**KIRKLEES COUNCIL
TOWN AND COUNTRY PLANNING ACT 1990
HIGHWAYS DEVELOPMENT MANAGEMENT**

PLANNING REF 2017/60/90688/W0/FT
CATEGORY Minor

PROPOSAL OUTLINE APPLICATION FOR
ERECTION OF RESIDENTIAL
DEVELOPMENT

LOCATION LAND BETWEEN 30 & 60
COMMERCIAL STREET
SLAITHWAITE
HUDDERSFIELD

Drawings Title: Proposed Site Layout

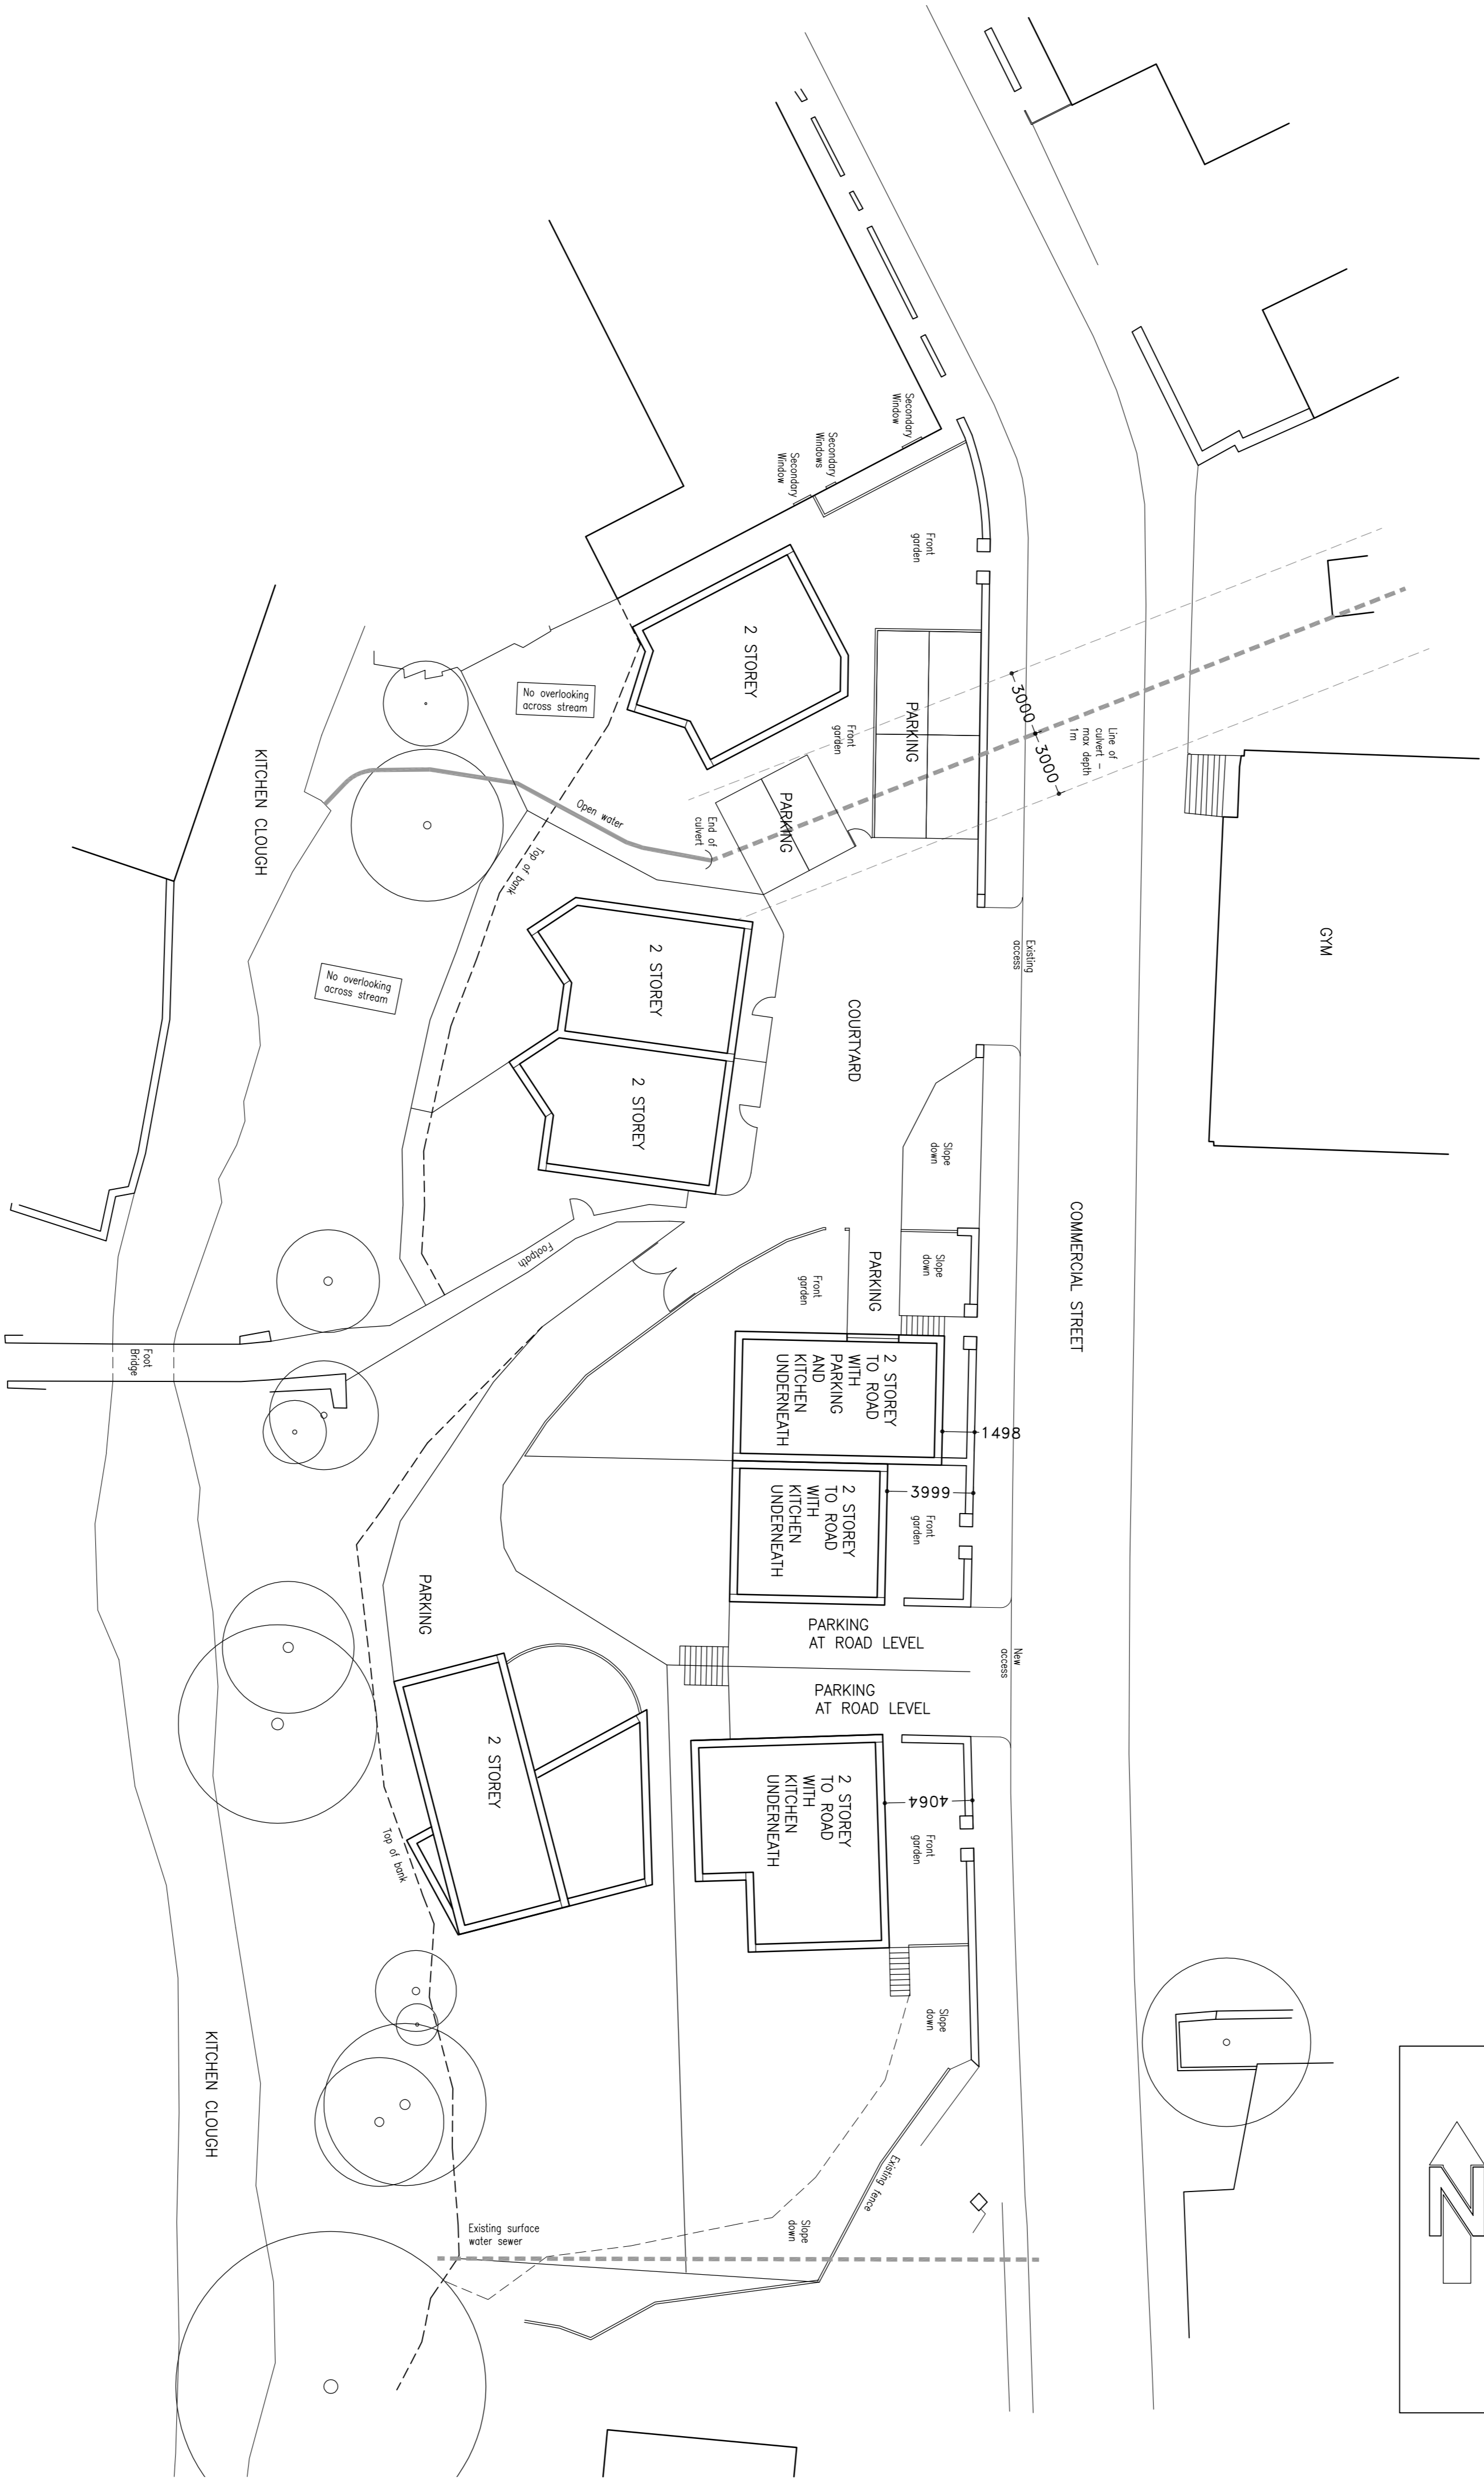
The existing footway on the site frontage is currently in need of reconstruction, this will also require localised kerbing works to accommodate new vehicular access points as indicated on the proposed site layout drawing.

The proposed development has indicated some provision for parking, this however appears to be inadequate for the size of dwellings proposed. The number of parking spaces for each dwelling should be demonstrated in accordance with Kirklees Councils parking standards to enable a HDM informed decision.

There is currently no provision for refuse storage within the property boundaries. Before development commences details of storage and access for collection of wastes from the premises will need to be provided.
